2025/0678

Brown Vehicle Compound, Carr Green Lane, Mapplewell, S75 6DY

Erection of five detached dwellings.

VIEW FROM CARR GREEN LANE.

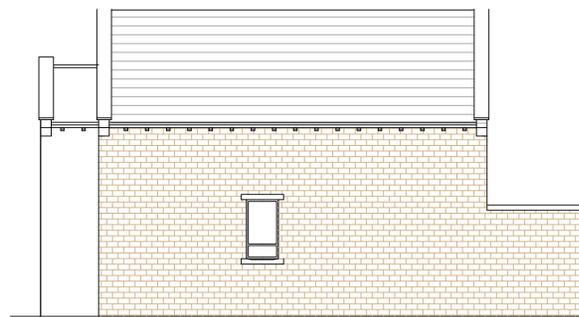
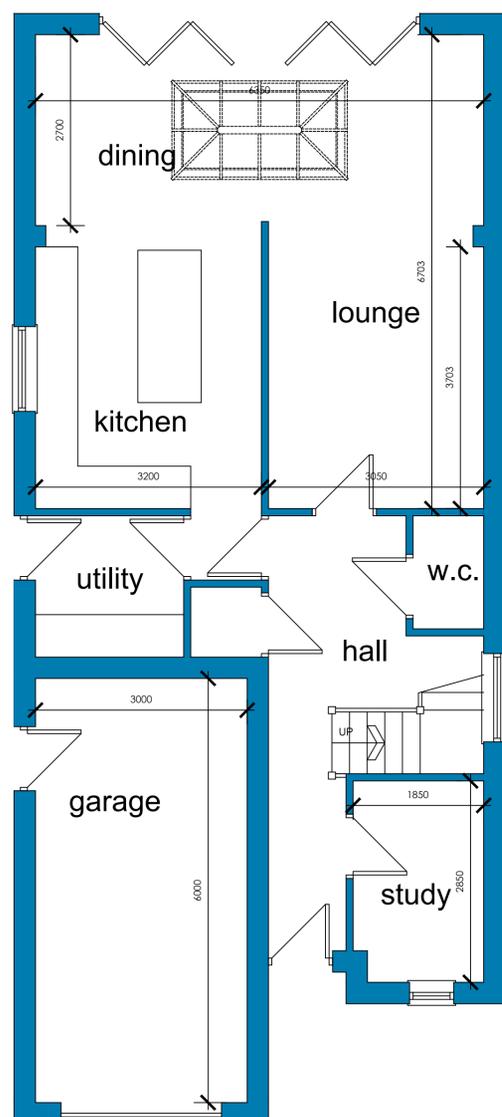
The proposal has been amended to reduce the impact of Plot 5 on the adjacent property at No. 68. The original design featured a pitched roof with side-facing gables, positioned approximately 3.5 metres from No. 68's south-facing balcony. This arrangement was considered visually intrusive and likely to restrict natural light. In response, the dwelling has been reoriented so that the gable now faces the street, with the roof sloping away from No. 68. This design revision significantly reduces the visual dominance of Plot 5 and improves daylight access to both the balcony and the side elevation window of the neighbouring property. The amended proposal does not now encroach in the 25 degree exclusion zone from the side window of No 68 and is considered acceptable in terms of residential amenity.

Given plots 1-4 are to the south of plot 5 and No 68 Carr Green Lane it is unlikely that any harmful overshadowing would occur to any surrounding neighbours. The 25 degree rule is met between plot 5 and No 68 and due to the positioning of the properties in relation to the sun's path no harmful overshadowing or loss of light would occur.
